From: Rachel . <blparishclerk@outlook.com>
Sent: 21 March 2023 14:26
To: Planning
Subject: 3/2023/0165

Planning application 3/2023/0165

Development	BILLINGTON		
Location	NEDDY LANE		
Marketing Name	CALDER GRANGE		
Drawing Title	Hall Road Layout		
Drawing Number	4441 / Eng / 440-1	Revision	-
Drawn By	CLB	Scale @ A1	1:500
Checked by	-	First Issue	09.02.23

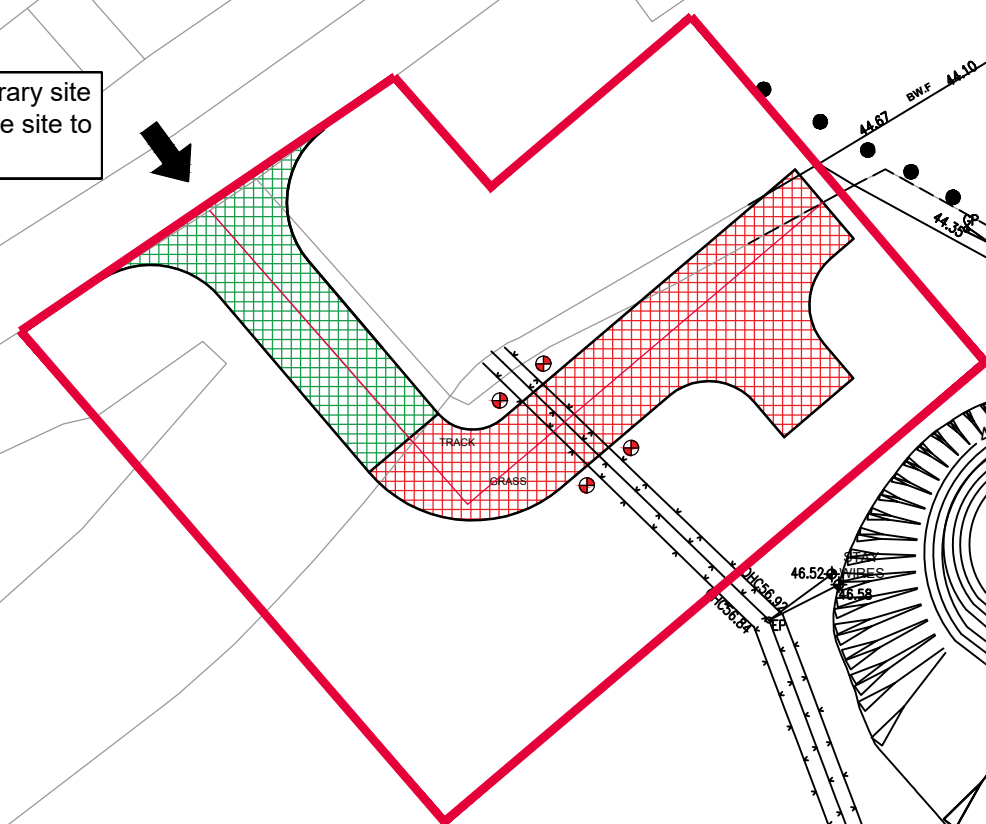
The safety aspect as construction vehicles will be pulling out into 60 miles per hour traffic, having HGV 's turning both on and off the road not safe.

Has planning considered the fact that vehicles would have to travel on and off the site during construction, this is all road users not just heavy construction vehicles.

Objections were raised on the grounds of road safety putting a 30 limit on the A59. Drivers will not be aware of this new speed limits to adhere to
